# BADGERYS CREEK

BURRAH PARK  
DESIGN RESPONSE

SBA ARCHITECTS  
LOT 1 DP 1306448

VEGETATION & WILDLIFE

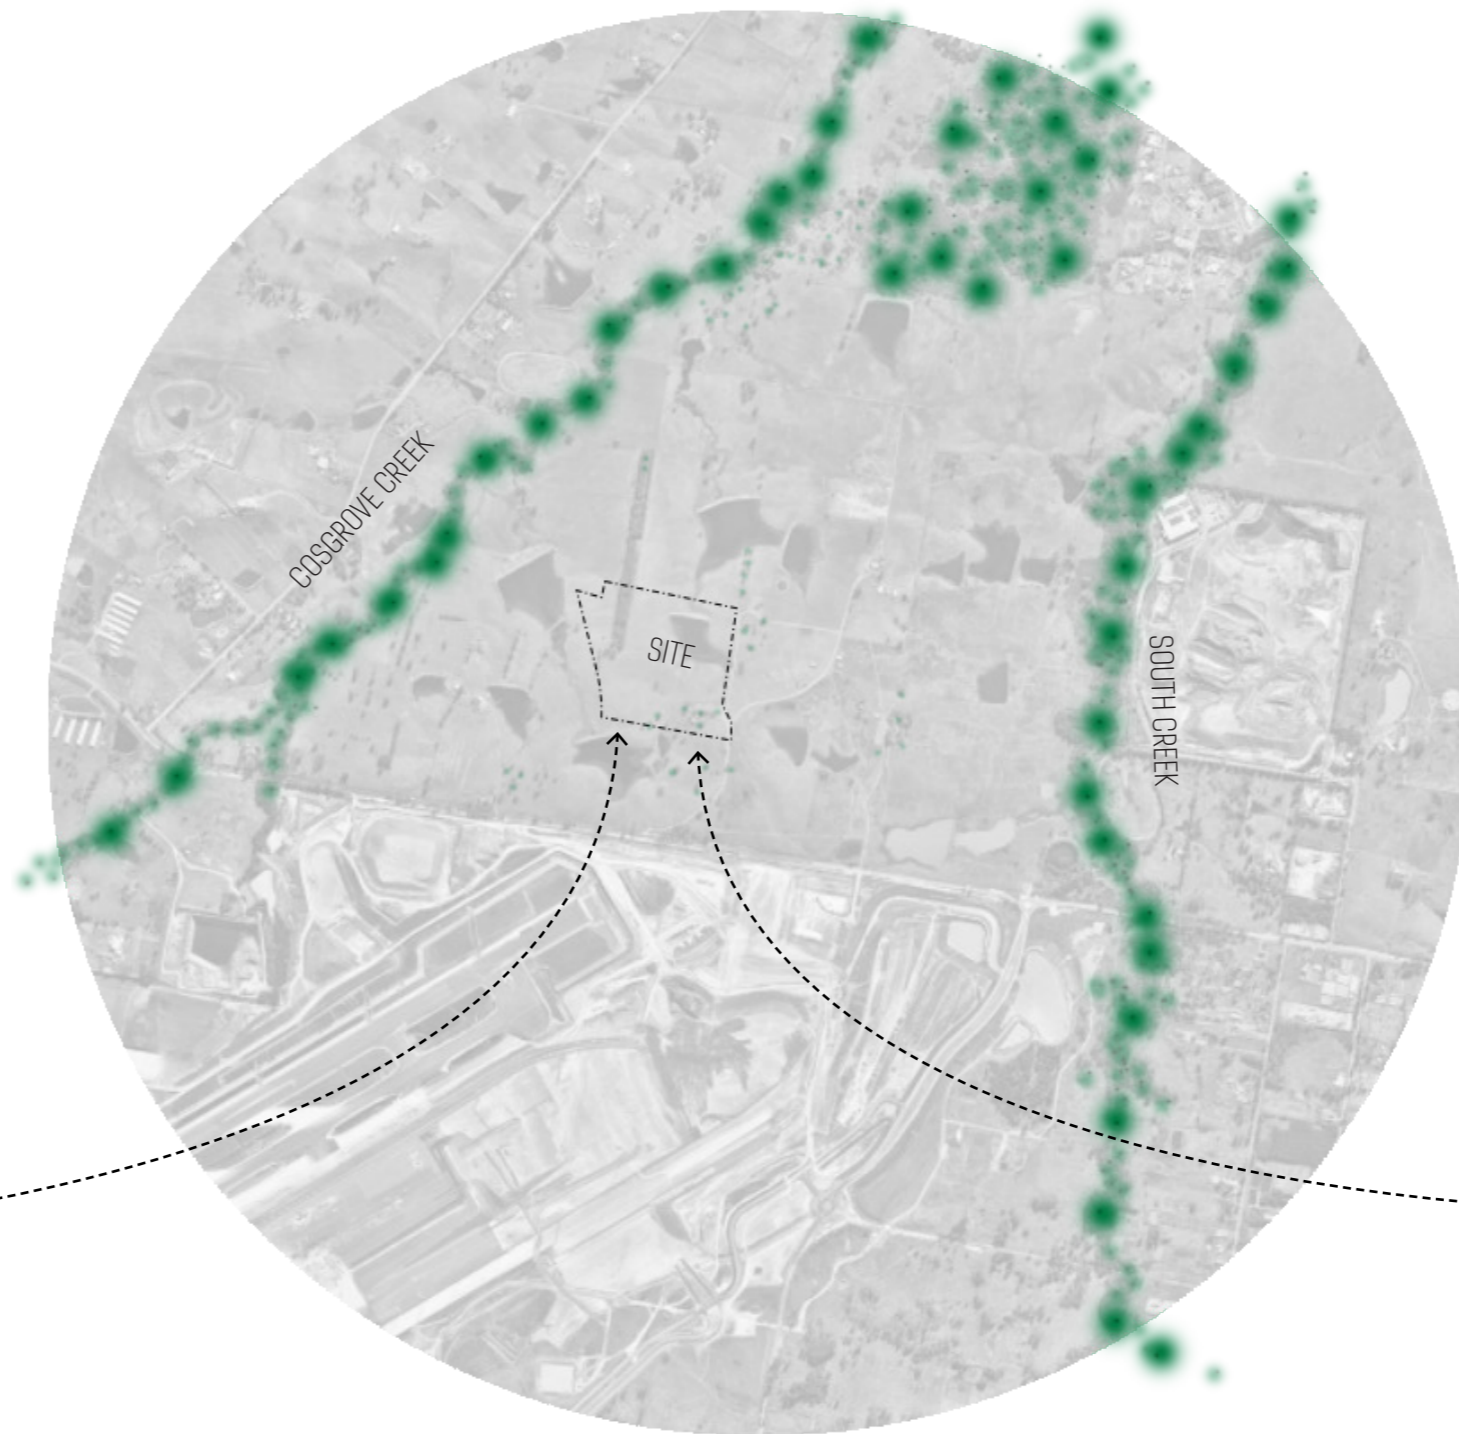
Refer to previous plant schedules. Endemic / native species, seasonality considered, bush tucker / medicinal species, pollinator beacons to attract insects.

The use of native flora species was gathered through collaboration with Yerrabingin and has been utilised into the landscape development, see pages 16 & 36 for details.

SUSTAINABILITY STRATEGIES

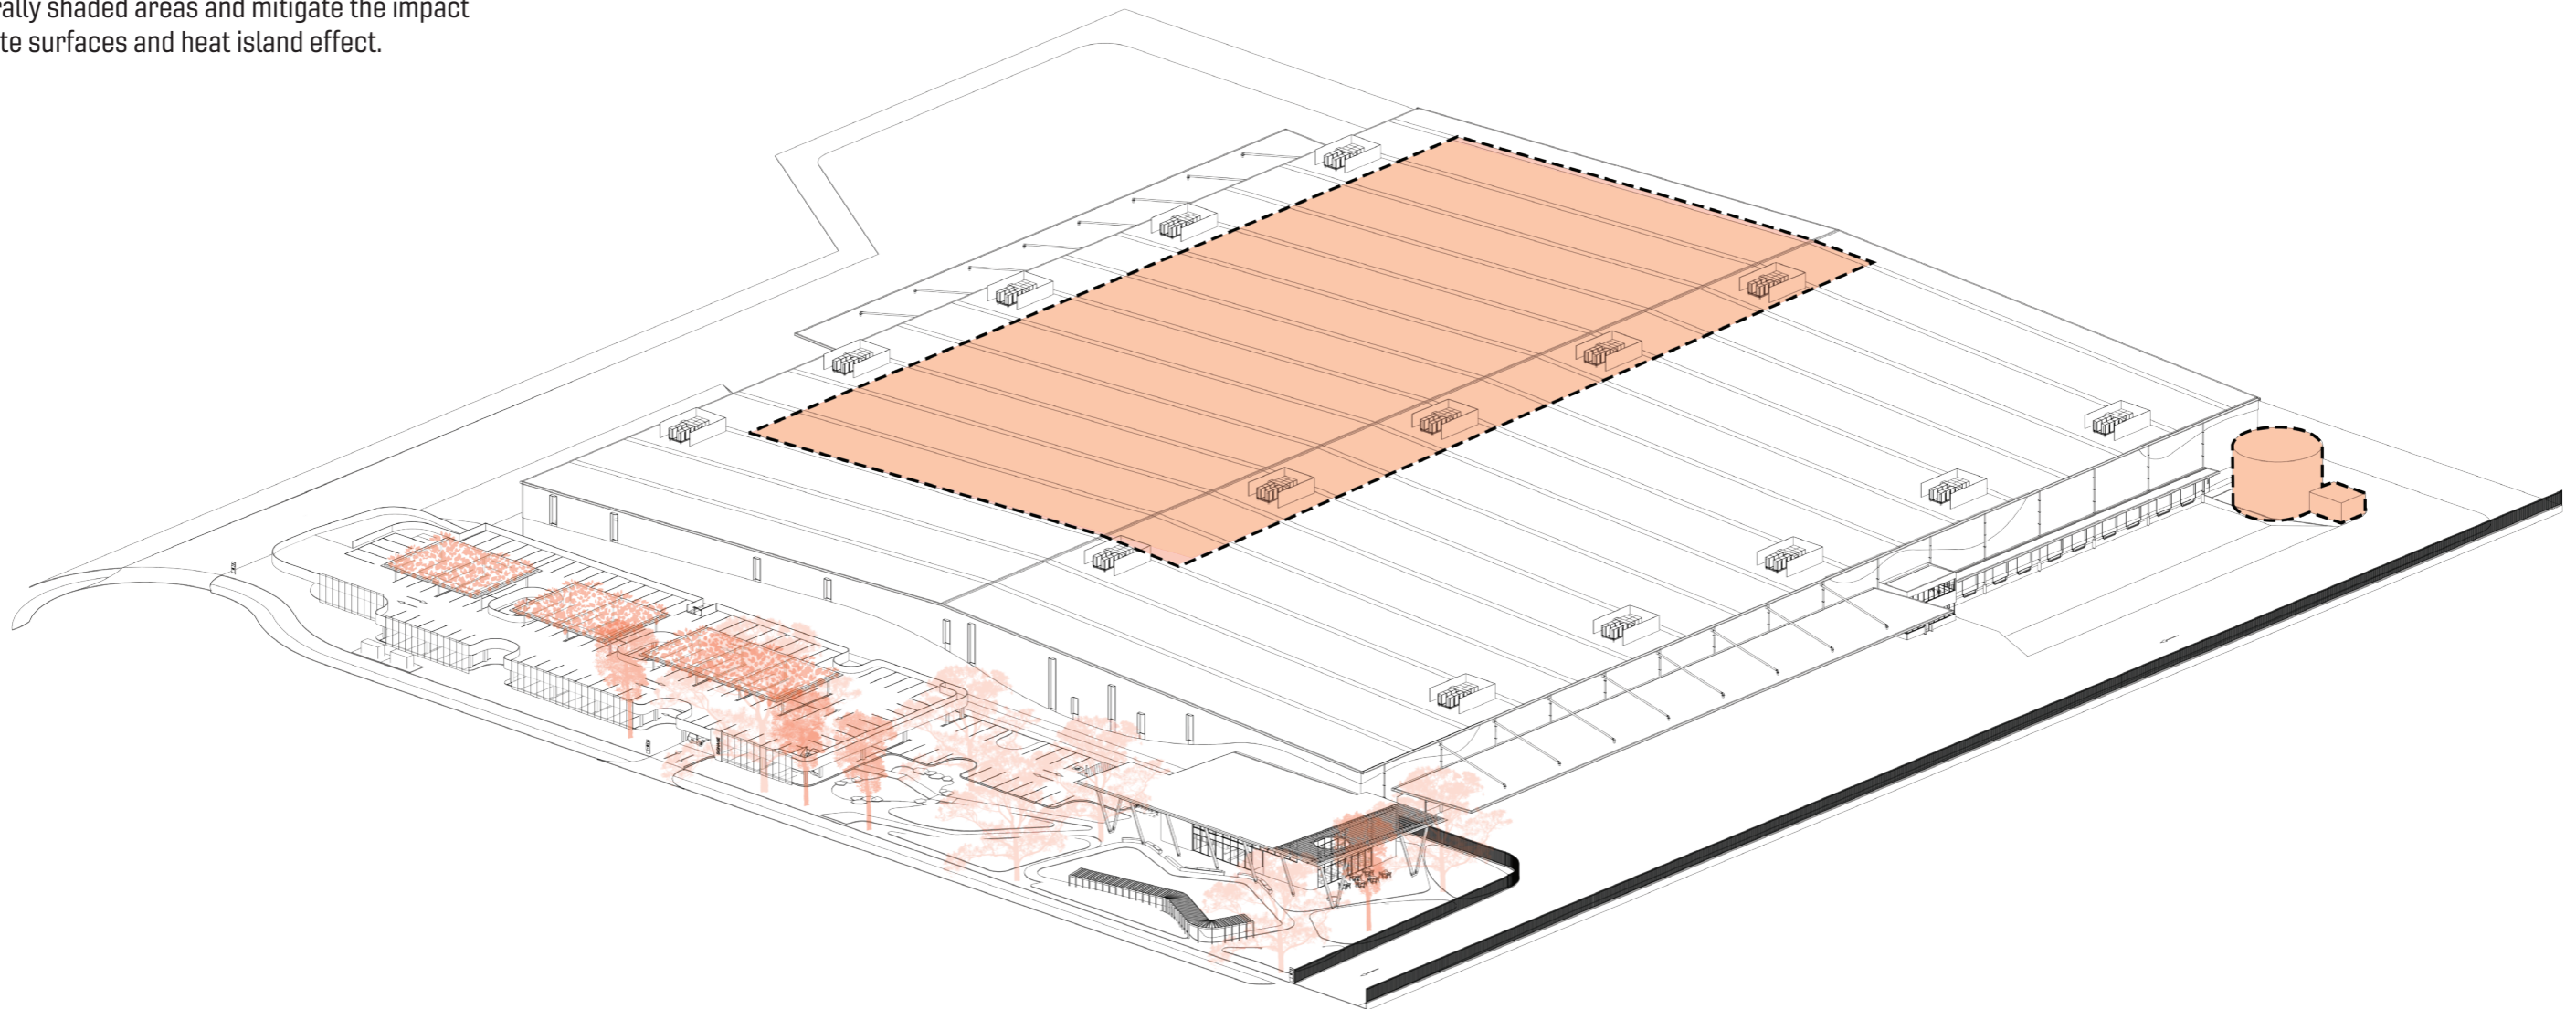
How rainwater will be treated on-site? Will the water be collected and reused?

Rainwater and other sustainability measure will be used to reduce the consumption of non-renewable sources, see page 46 for details.
